WELWYN HATFIELD COUNCIL – DEVELOPMENT CONTROL
DELEGATED REPORT

APPLICATION No:	S6/2012/0193/FP
------------------------	------------------------

The proposed development would involve the erection of a two-storey front extension and a single storey canopy roof to the western side of the front elevation. The proposed two-storey addition would measure approximately 5m in width (gable projection) with a wider roof extension by 6.2m in depth with a gable fronted design and ridge height of 7.4m.

Drawing title:
GENERAL ARRANGEMENTS
PLANS & ELEVATIONS AS PROPOSED

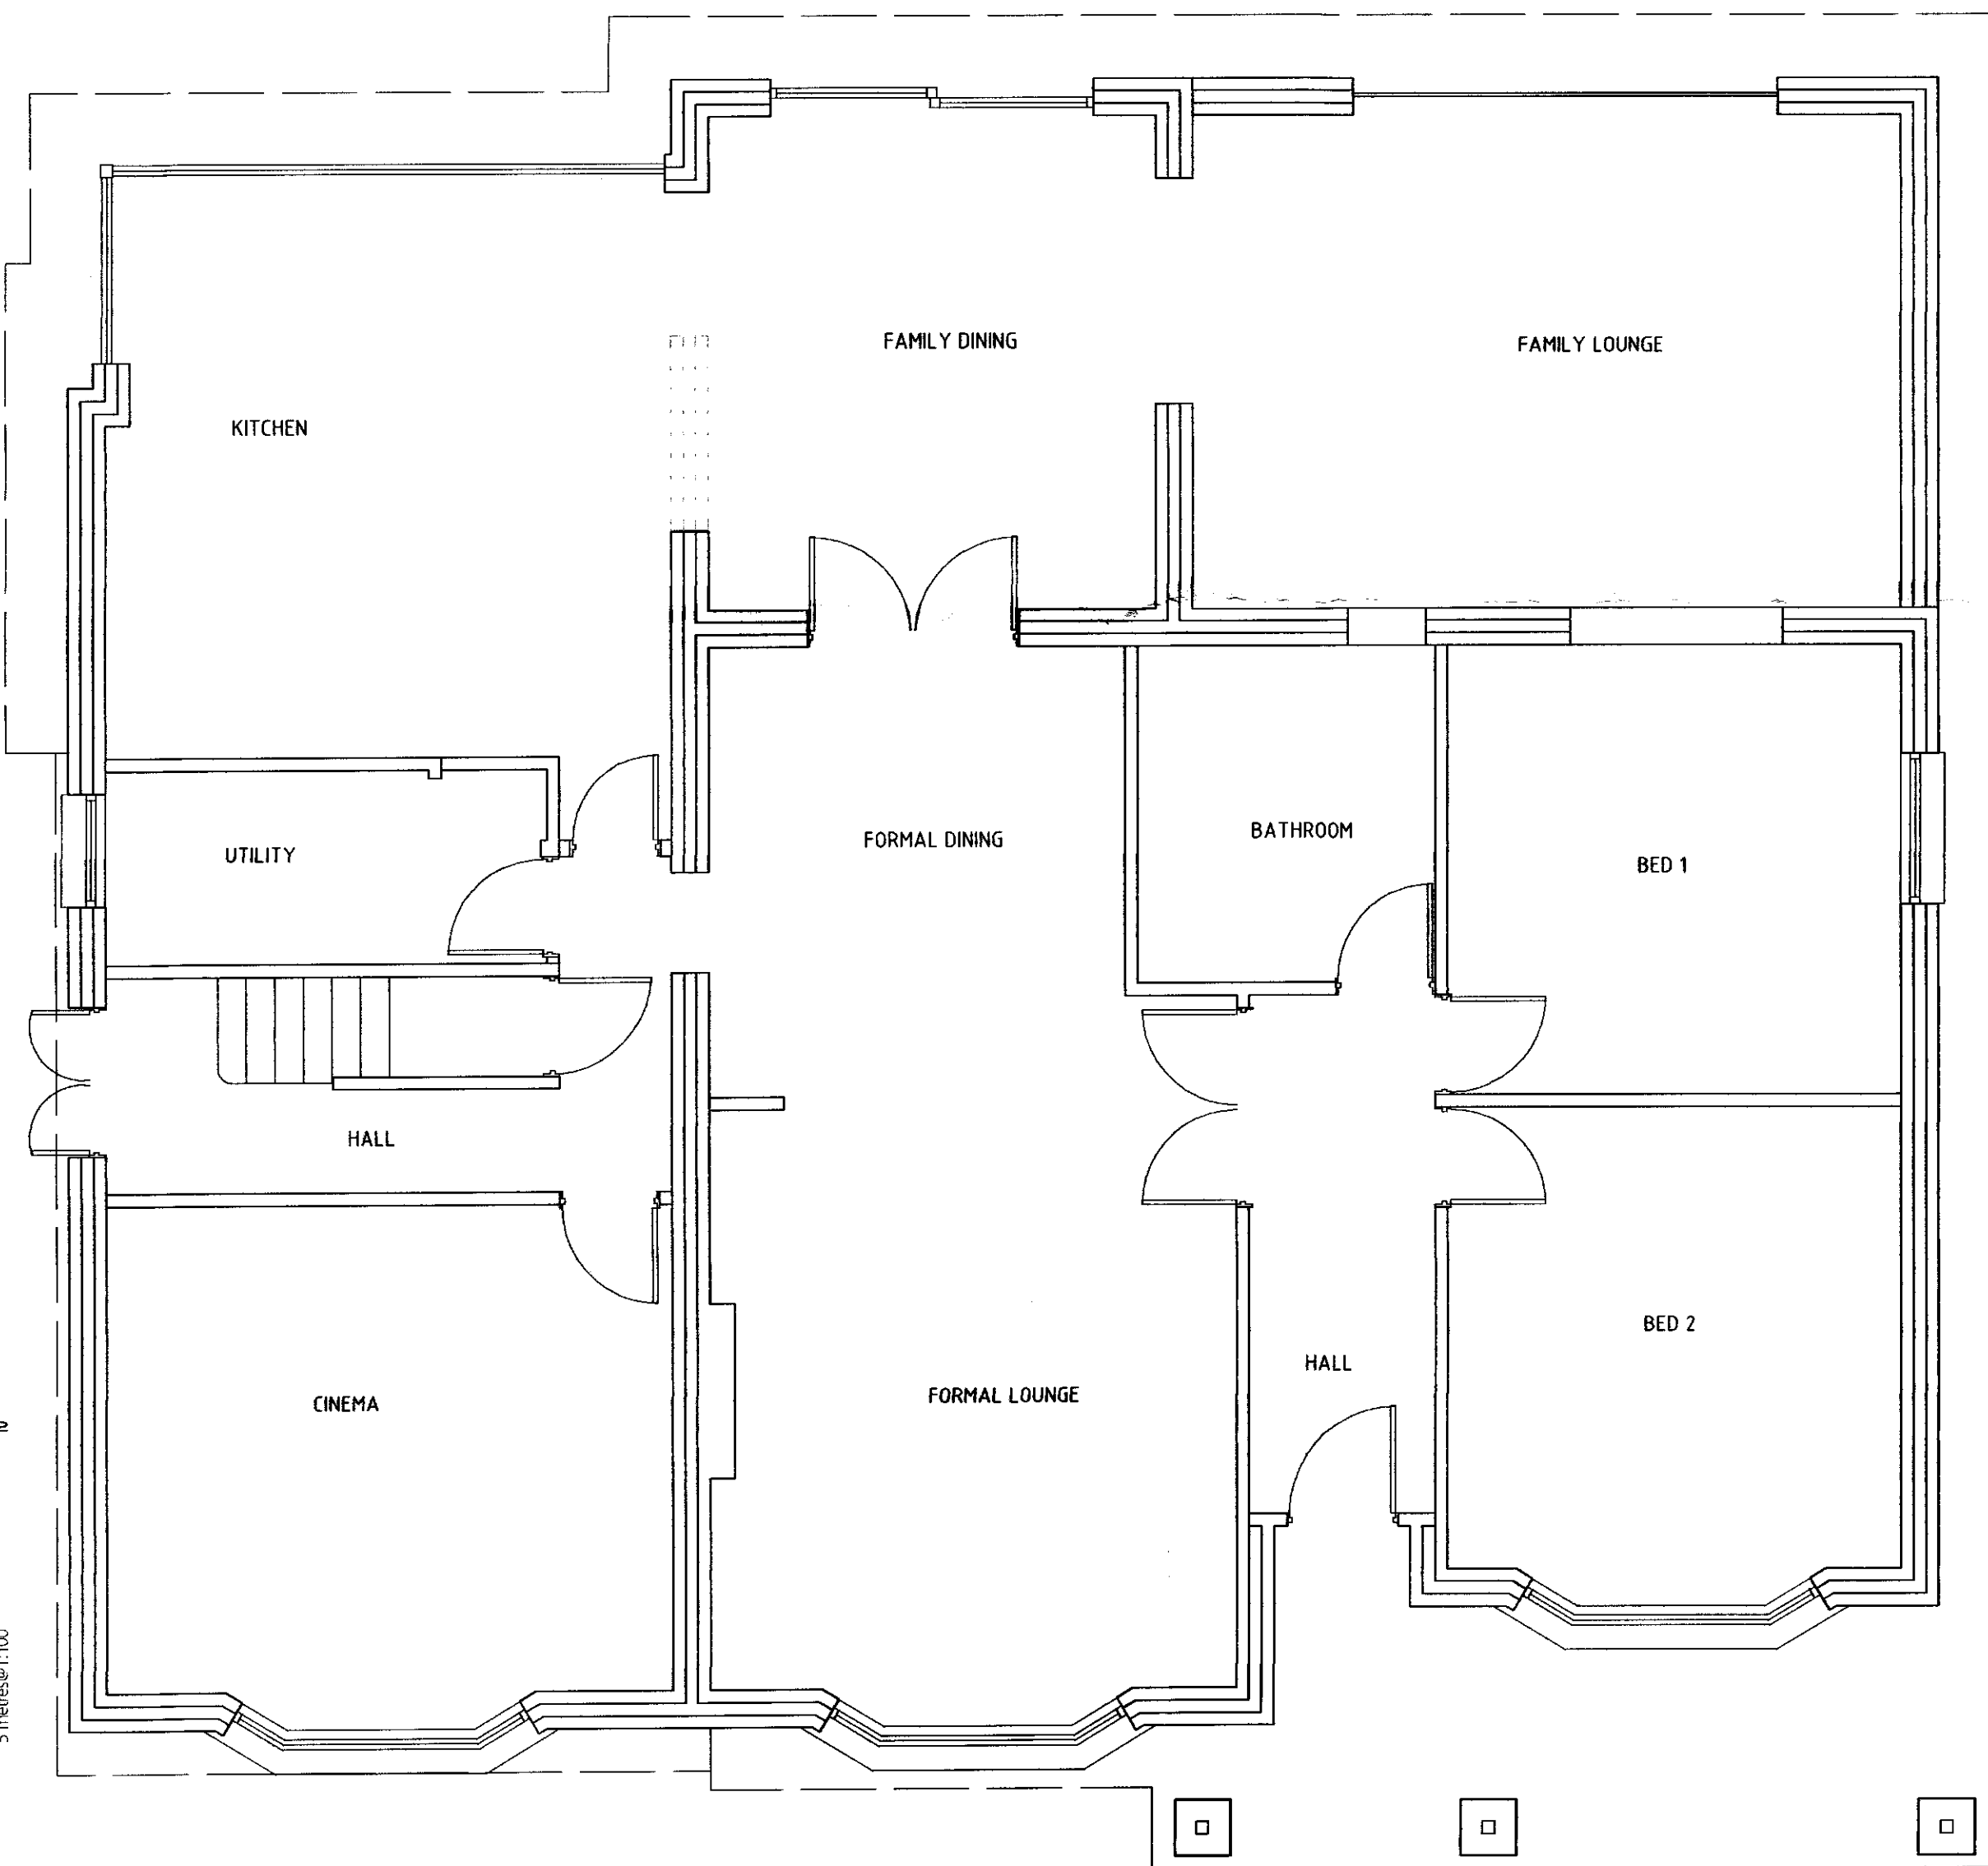
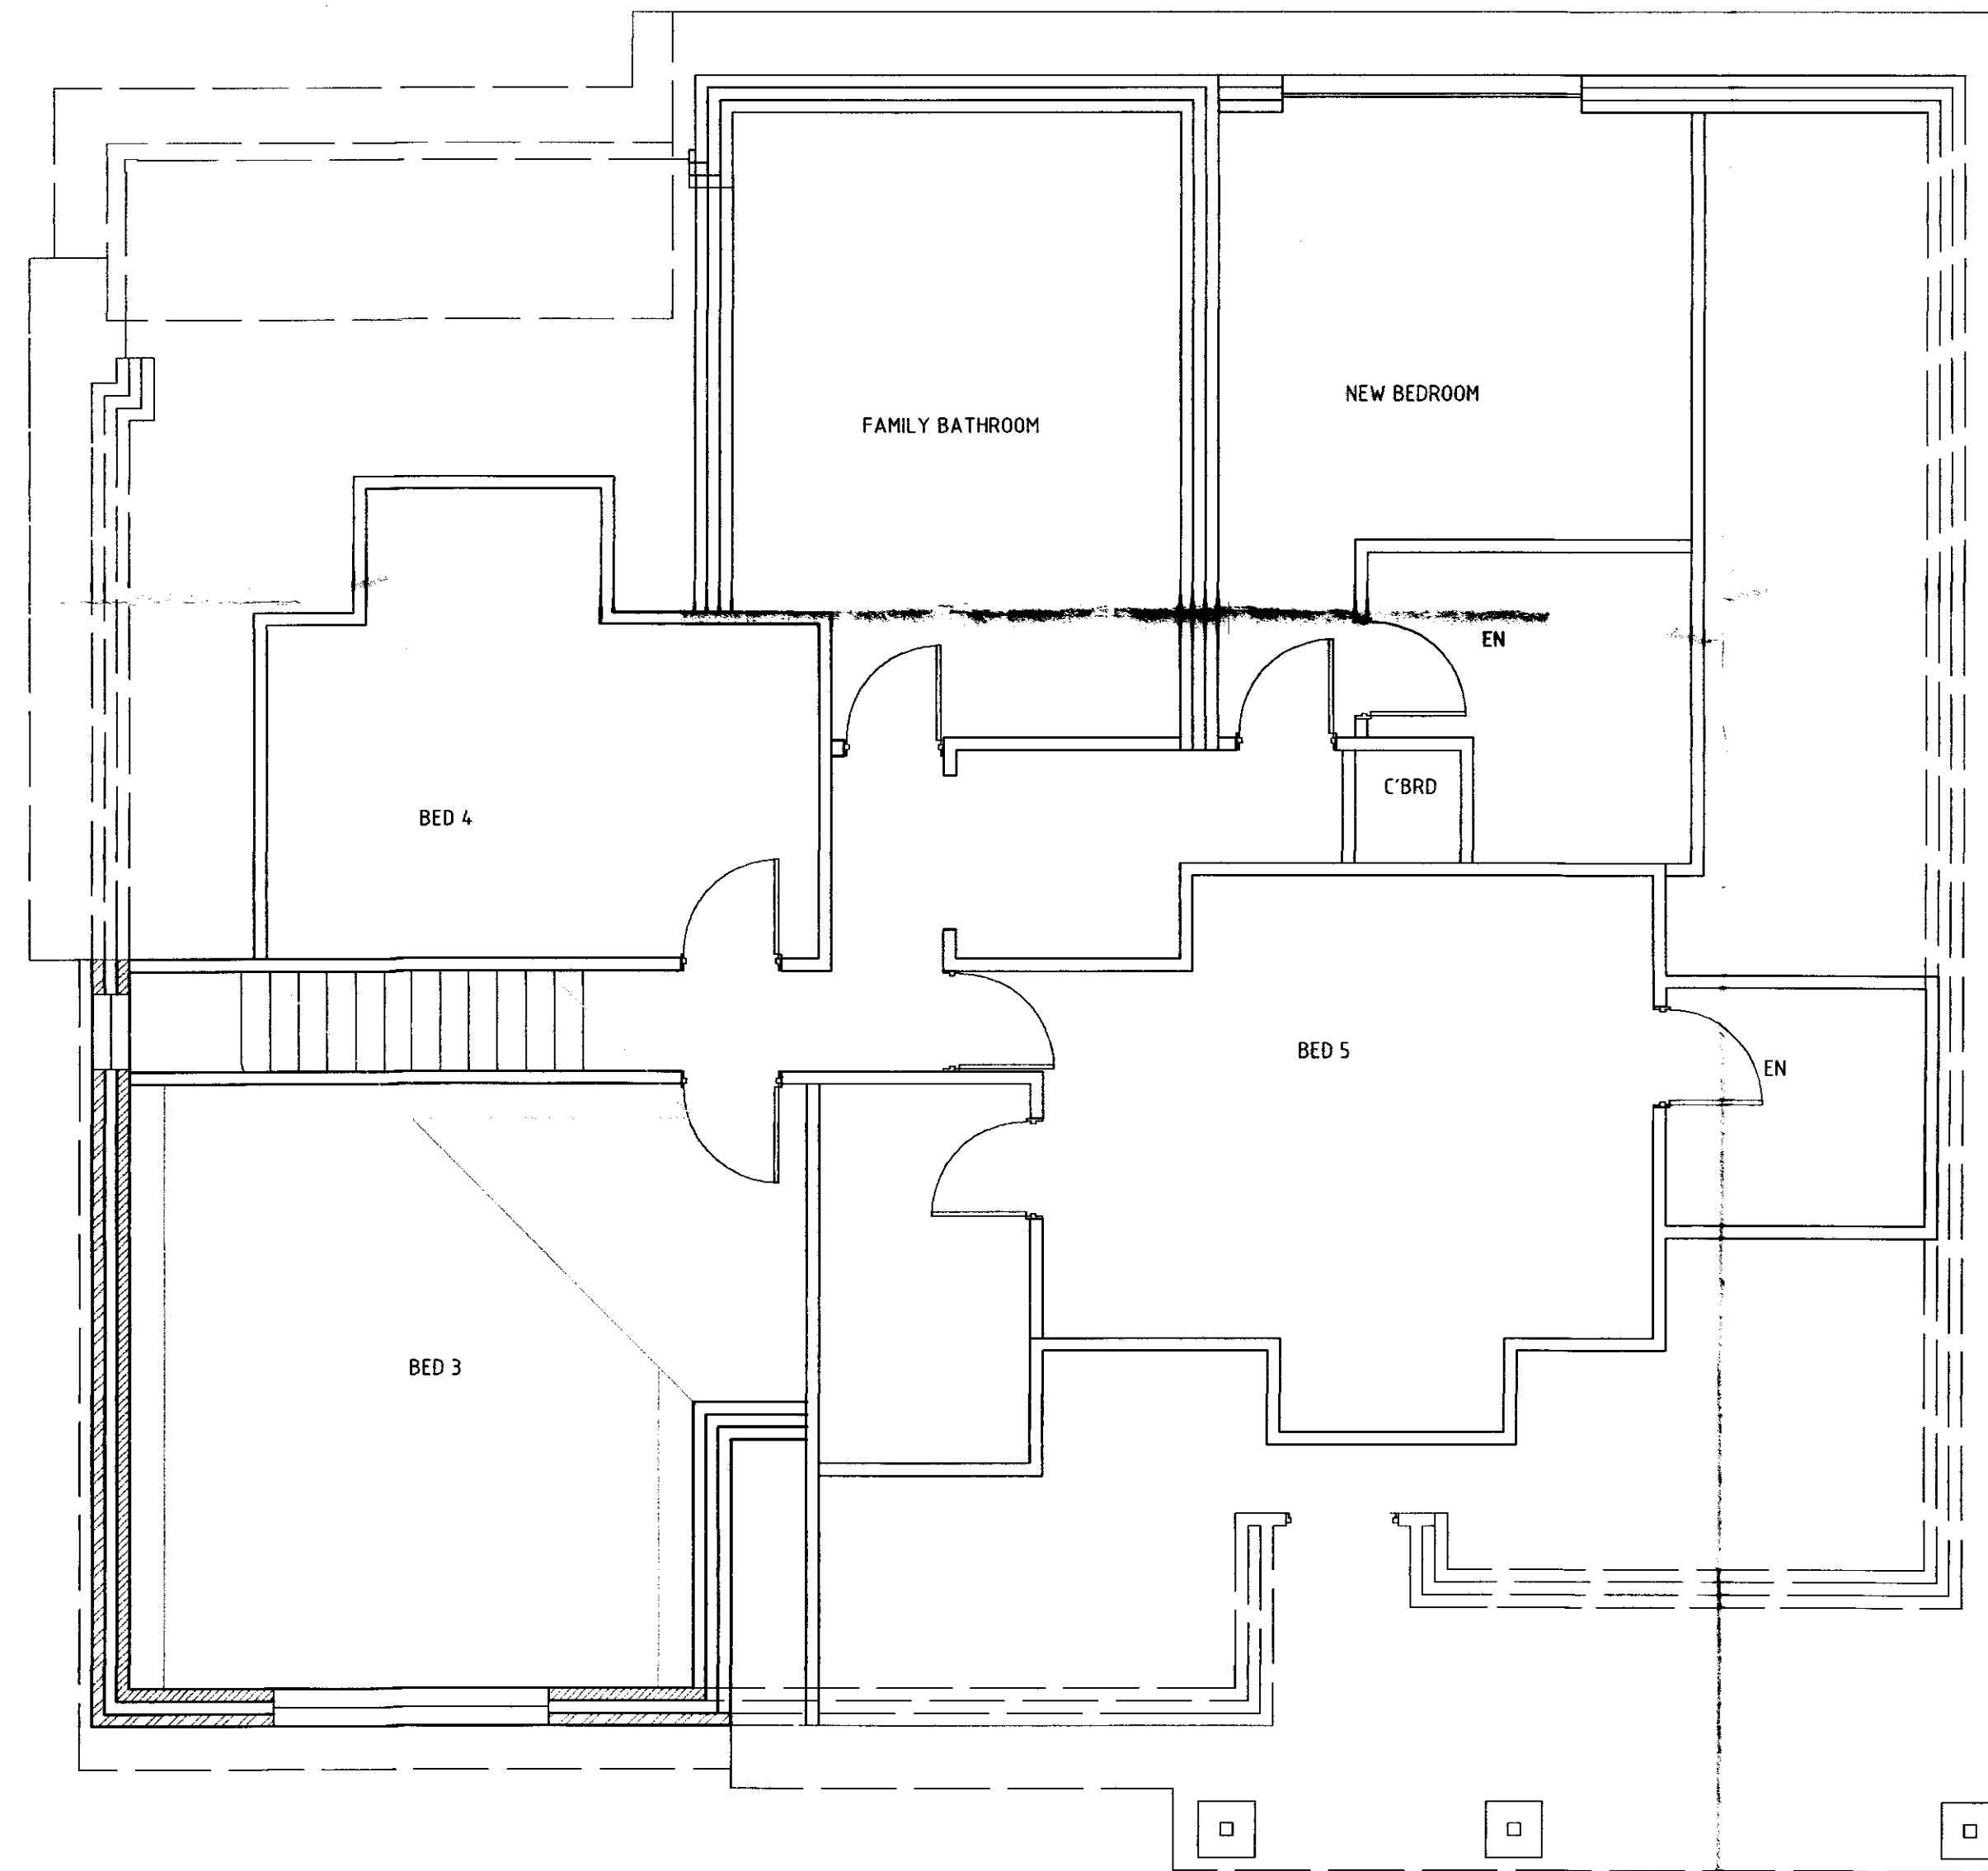
The proposed two-storey extension would partly give the dwelling a more dominant appearance and be less reflective of the bungalow appearance. However, the width of this addition would not dominant the dwelling's width and would not significantly detract from the original low rise appearance of the dwelling. Several of the surrounding properties are two-storey within close proximity to the application site and the resultant dwelling would not appear out of place when compare to these properties.

It has been noted that the proposal would have an unusual appearance to the side and rear and would not be particularly reflective of the main dwelling. However, this would not be viewed prominently or be seen from the surrounding public areas. The distance from the adjacent Listed Building to the west and outbuildings which sit between the application dwelling and this property would prevent the proposal from being viewed prominently from or with the Listed Building.

The proposed single storey canopy area would be relatively modest and would be have a hipped roof to reflect the design of the main dwelling. This addition would not appear overly prominent and would not have an adverse impact upon the character and appearance of the locality.

The proposed additions to the front of the property have been designed to be subordinate in depth and height which would ensure that the existing dwelling retains its existing appearance and features. The resultant dwelling would not have an adverse impact upon the character and context of the locality.

The proposal would only have one window which is to the rear elevation and this would not result in any significant overlooking or a loss of privacy to any of the neighbouring properties.
